Located At 236 PRESUMPCOT ST

Job ID: 2012-08-4735-ALTCOMM

FedEx – 236 Presumpscot Street – Application to install an above ground Fuel Storage Tank – Submitted August 17, 2012

FED EX TERMINAL
 236 PRESUMPTCOT ST, PORTLAND ME
 PROPOSED AST LOCATION SKETCH
 7-30-12

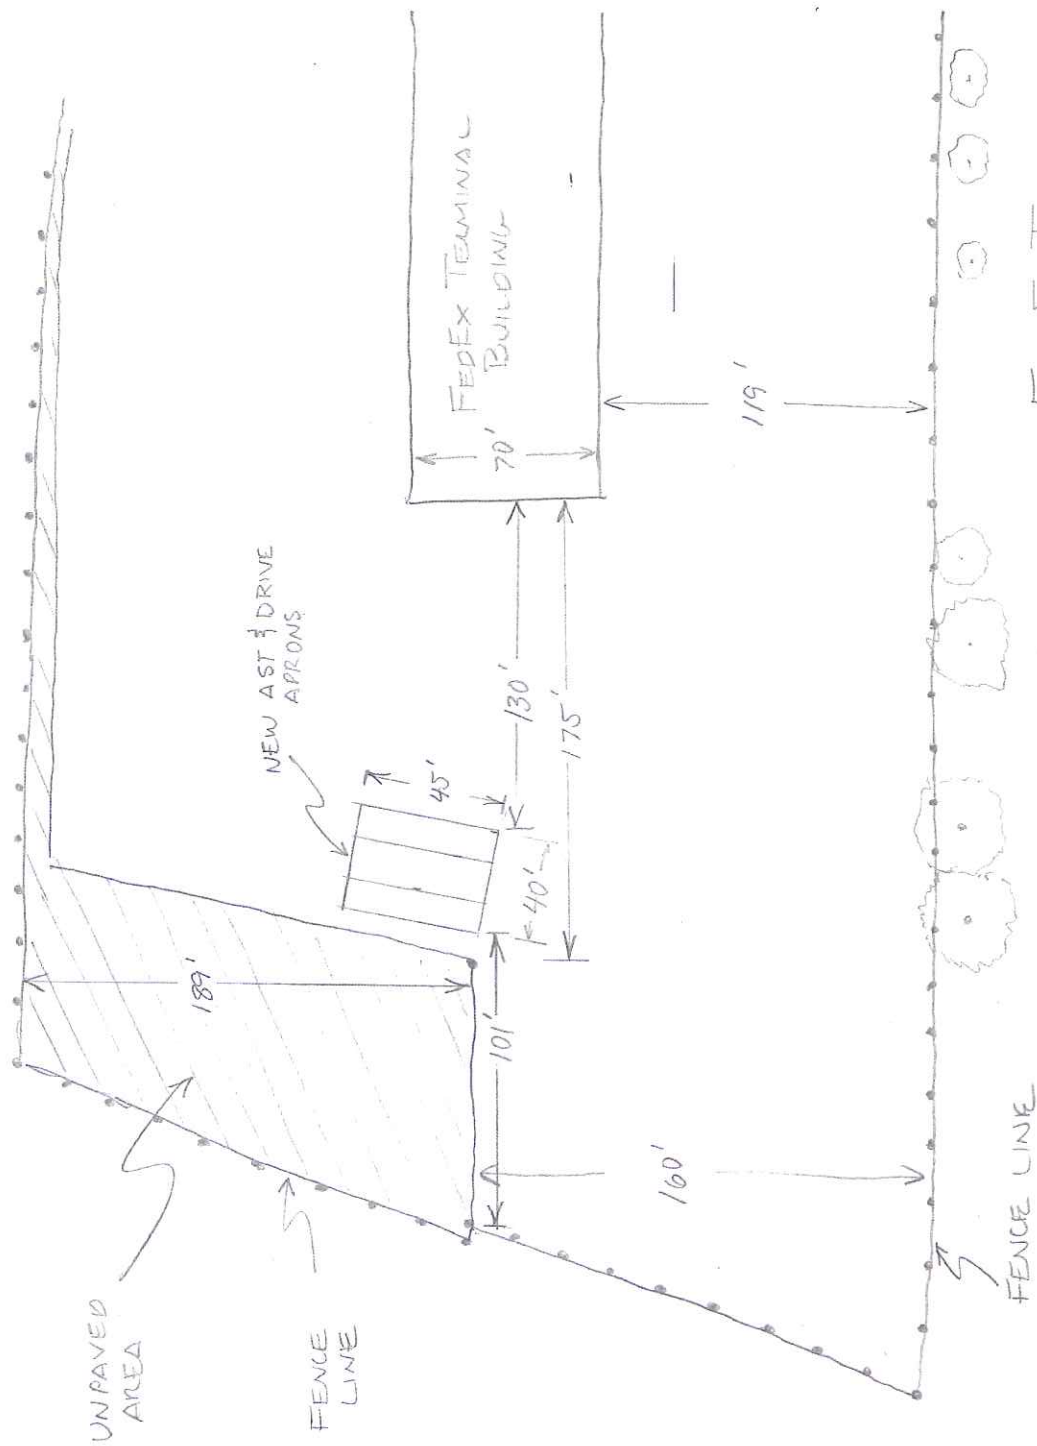
I have done the review of this permit and have a code question per the IBC 2009. Sec. 406.5.2. The vehicle needs to be fueled on a noncoated concrete or other approved materials having a resistance not exceeding 1 megohm as determined by the methodology in EN 1081.

Can you please provide specs on the pad and the drive mat to be installed?

I don't see the site plan showing where on the site the tank is to be located. Could you forward it along?

For the planning review, I would like to know where on the site the pad and tank will be located (I see you have 3 options) and any other site improvements that may be proposed, such as bollards or screening of the tank. Also, could you please give me the volume of the tank and what will be stored in the tank. Lastly, does this require any permits from DEP?

- the pad and drive mat will be non-coated concrete.
- The tank pad will be 10" thick with #4 rebar 12" on center running both ways
- The drive mat will 8" thick with 6x6 wire mesh reinforcing
- A 4,000# air entrained concrete mix will be used for all of the slabs noted above
- All slabs will have a broom finish

I went to the site this weekend and took measurements from the building and from the fence lines. I have attached a sketch as well as two aerial photos of the site. I hope this answers your questions. Please let me know if you need anything else and I will do my best to get it for you.
